From: Amber Willard
Sent: 28 January 2019 09:28
To: Karen Parsons
Subject: FW: 1 Church Farm Cottage, Yapton.

I am currently writing up Y/81/18/HH for the loft conversion and dormers however on looking at the plans I believe the elevation may be incorrect. On the block plan/ location plan (171164/06) the dormers are shown facing the northern elevation with Velux windows to the south. Whereas on the plans and elevations as proposed (171164/02) the dormers are to the southern elevation and velux to the north.

I am looking through the various applications at the site of 1 Church Farm Cottages, Yapton for Y/80/18/PL, Y/83/18/HH and Y/81/18/HH.

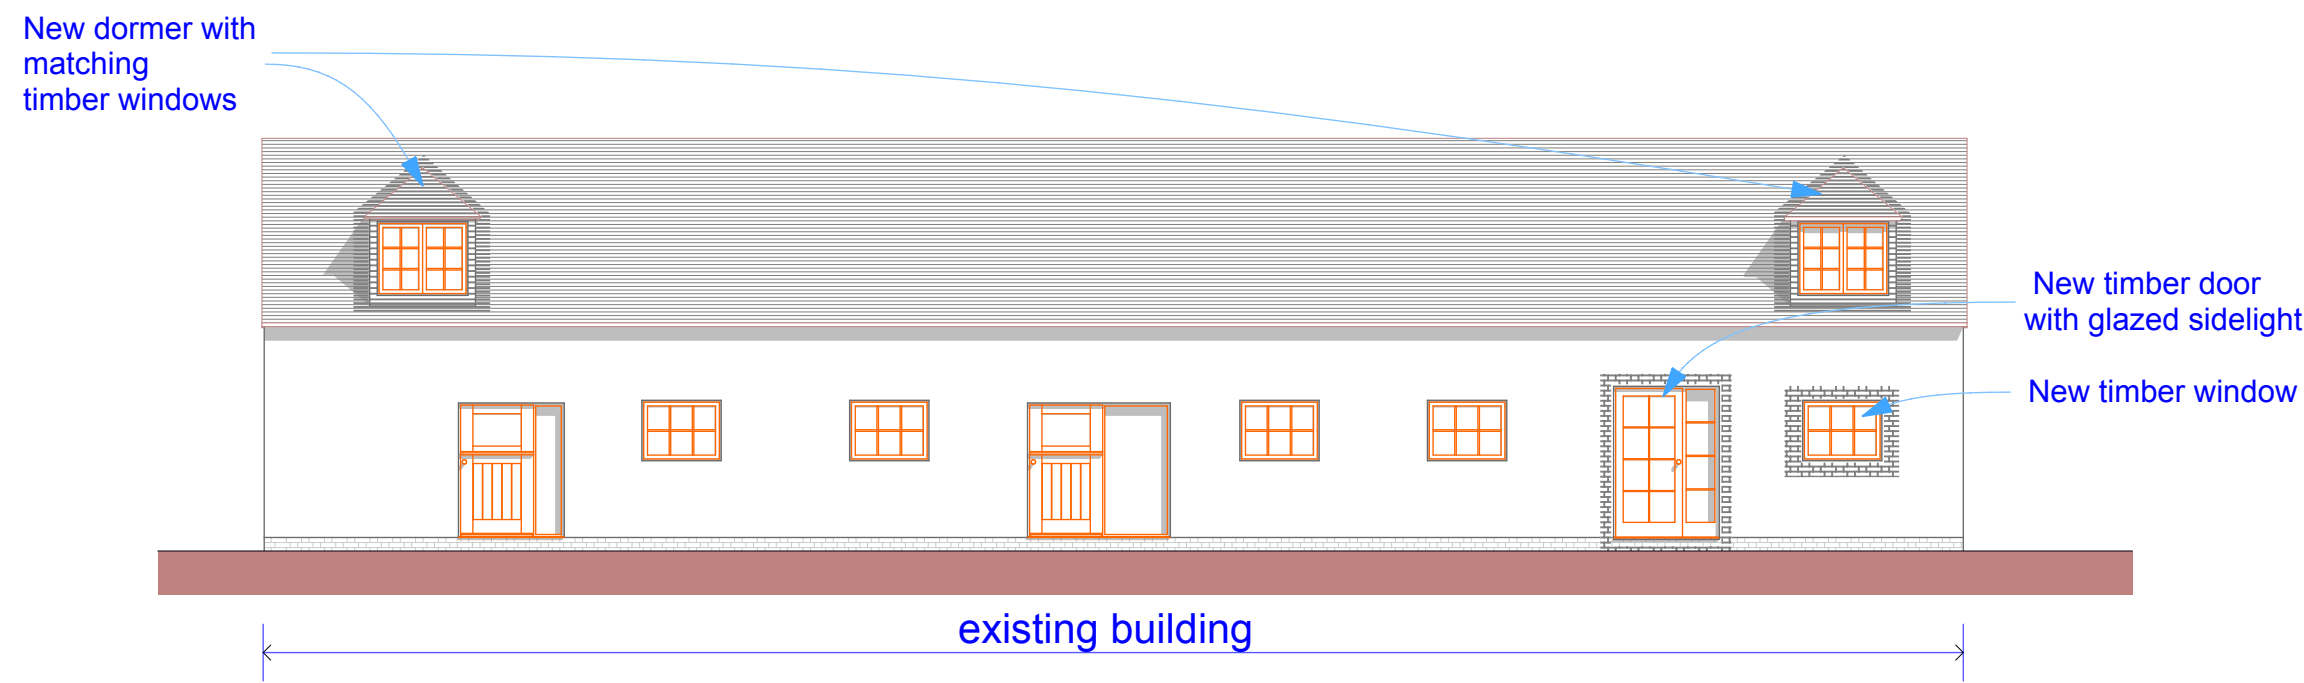
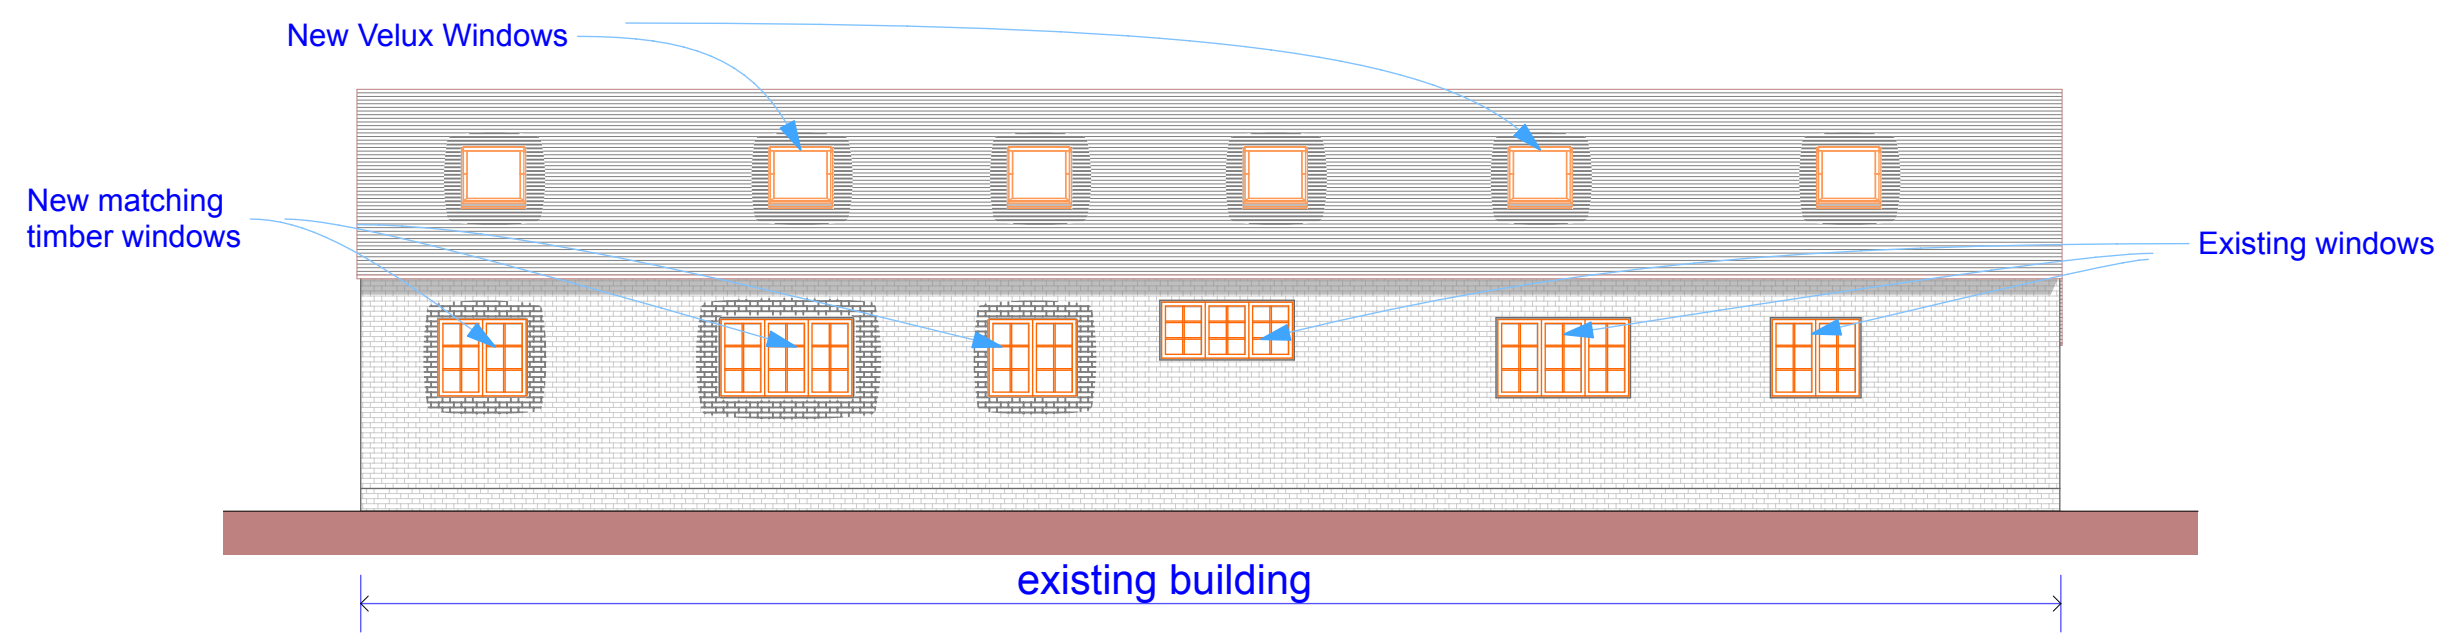
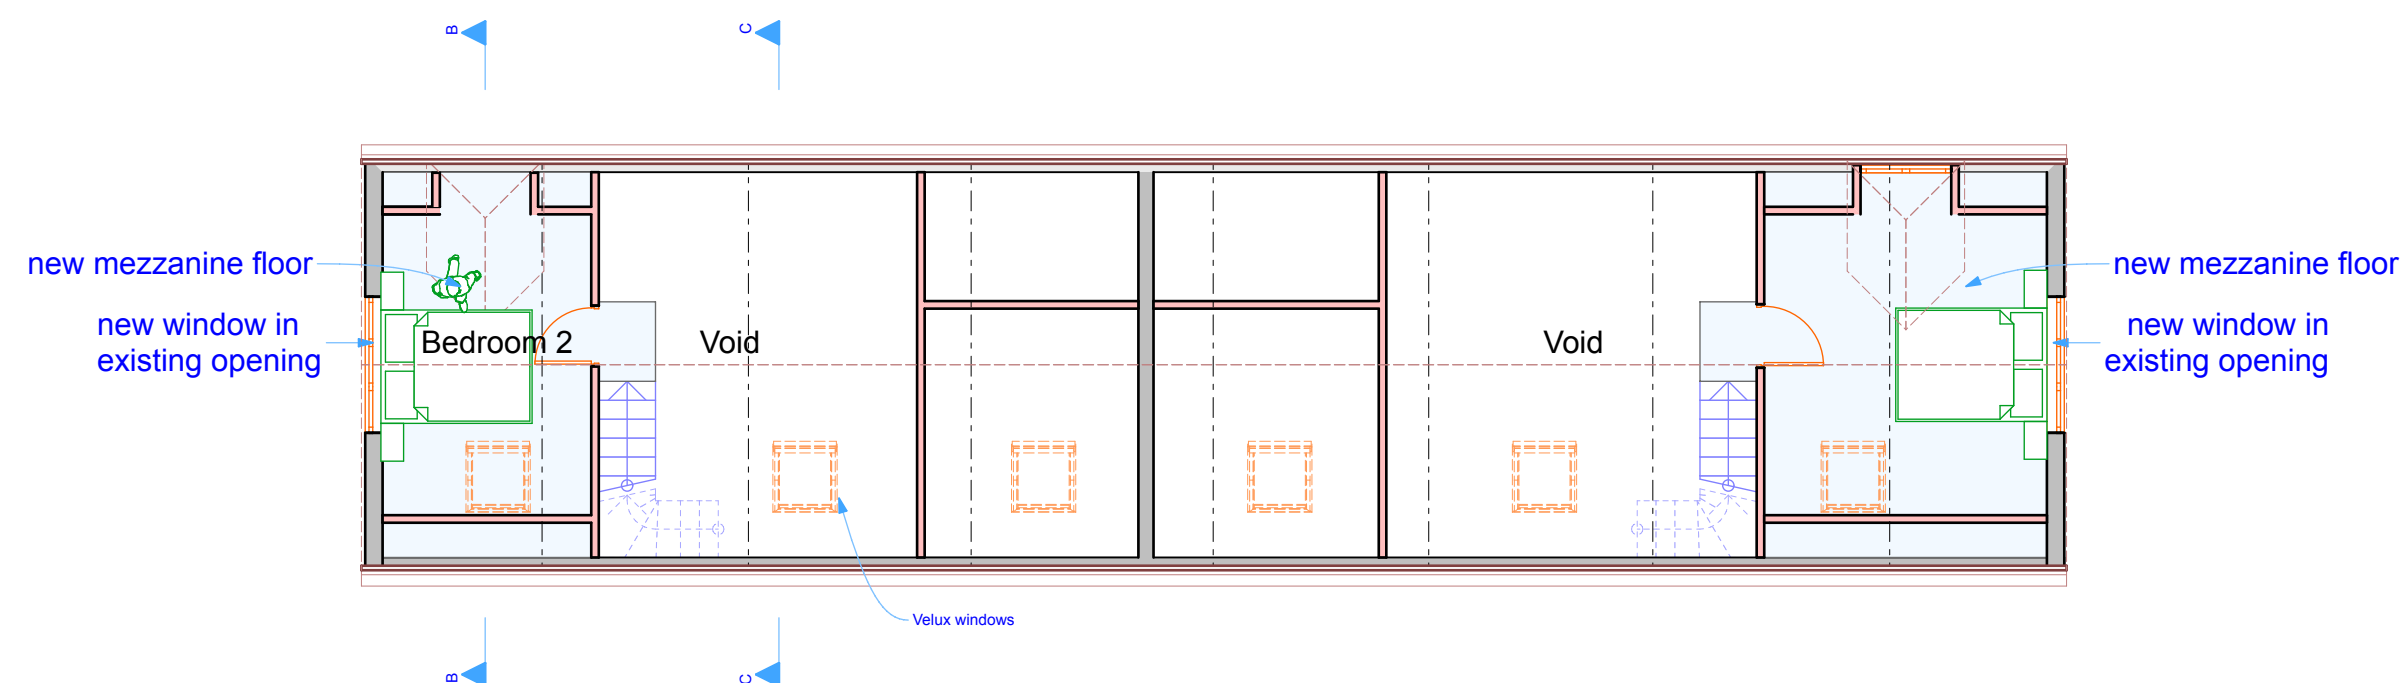
Please can you confirm which elevation the dormers are and amend the plan as necessary.
